PCD FILE NO: VR2313

MINOR SUBDIVISION PLAT
HILL SUBDIVISION FILING NO. 1

Re: *Minor Plat Comments VR2313*
Project No. 61174

HILL SUBDIVISION FILING NO. 1

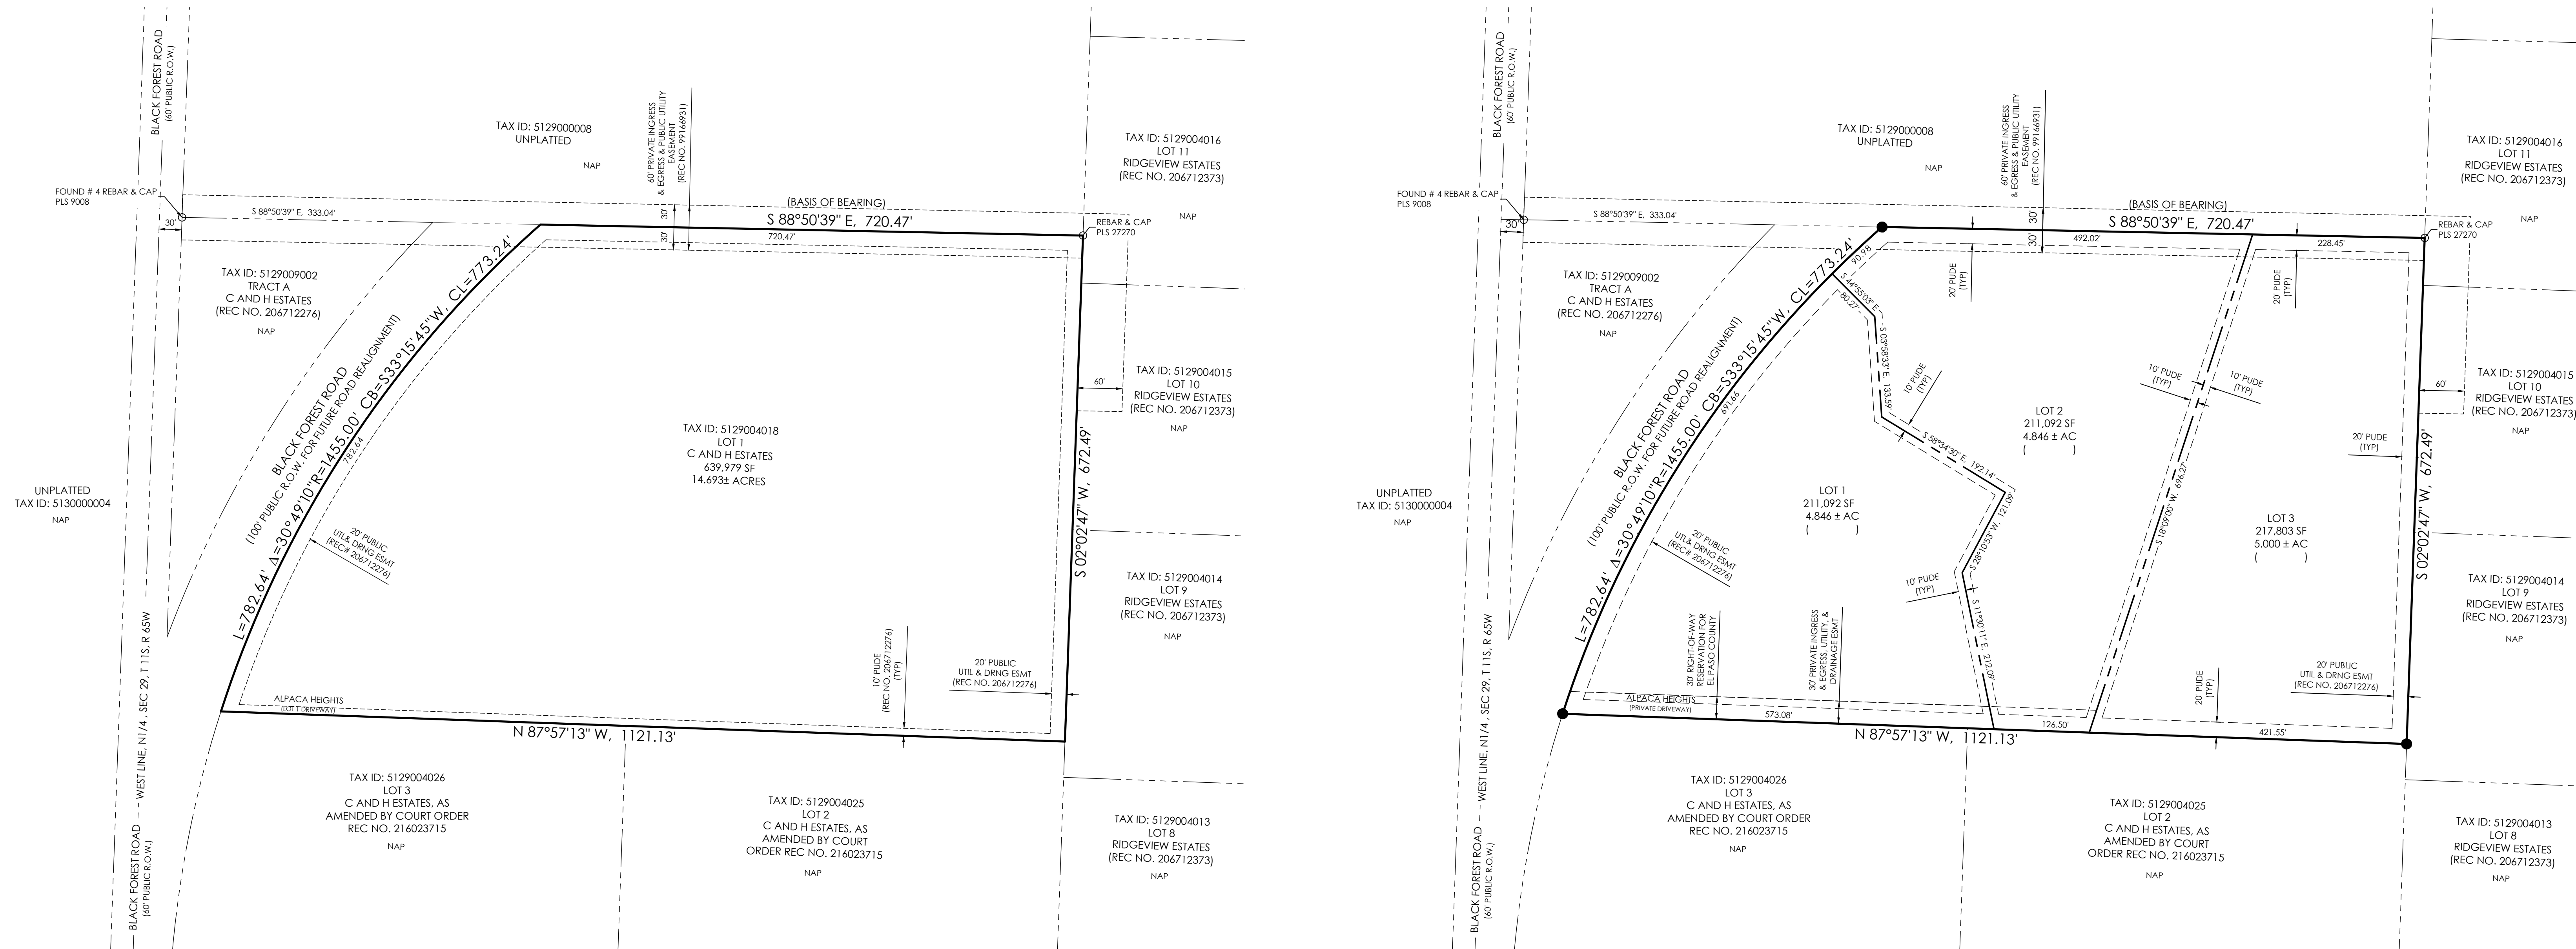
1. *“Lot 1 C And H Estates, As Amended By Court Order Rec #216023715”*
The title/subtitle should not include documents that add, subtract or remove easements from the property. The court order does not amend the plat, it Extinguishes an Easement. Should this comment be enforced, the subtitle of the plat should therefor include all documents that affect the property. It is not reasonable to include every affecting document in the title of the Plat.

3. *“Depict the areas of geologic constraints as they are noted in the soils & geology report and designate them as no build areas.”*
The soils report outlines mitigation measures for all of the shown geologic hazards. No build areas should not be created for hazards that can be mediated through proper engineering design and construction practices.

4. *“Please identify which lot will own tract A. previous plat indicated that Lot 1 was the owner but now lot 1 is subdividing into 3 lots.”*
Tract A is outside of the boundary of this Plat. This plat only vacates and amends areas within the boundary of this subdivision. It already has ownership. Should this comment be enforced, it would link the ownership of one of the lots to the ownership of Tract A. The sale of the lot would therefor automatically grant Tract A to the new Lot owner. It for this reason that plats do not grant ownership.

5. *“Include the notes that say not a part of this subdivision”*
NAP (Not a Part of this Subdivision) was added to the legend and added to each surrounding property. Please note that the intention of the NAP note is to show areas WITHIN the boundary that are exempt and not a part of the subdivision. In this particular subdivision there are no areas

within the boundary that are not included. The very nature of a “Boundary” designates the area that is being platted and separates it from that remaining 2,130 square miles of El Paso County that is not being platted. To designate every parcel that is OUTSIDE of the boundary as not a part is redundant and does not coincide with the intent of the note.
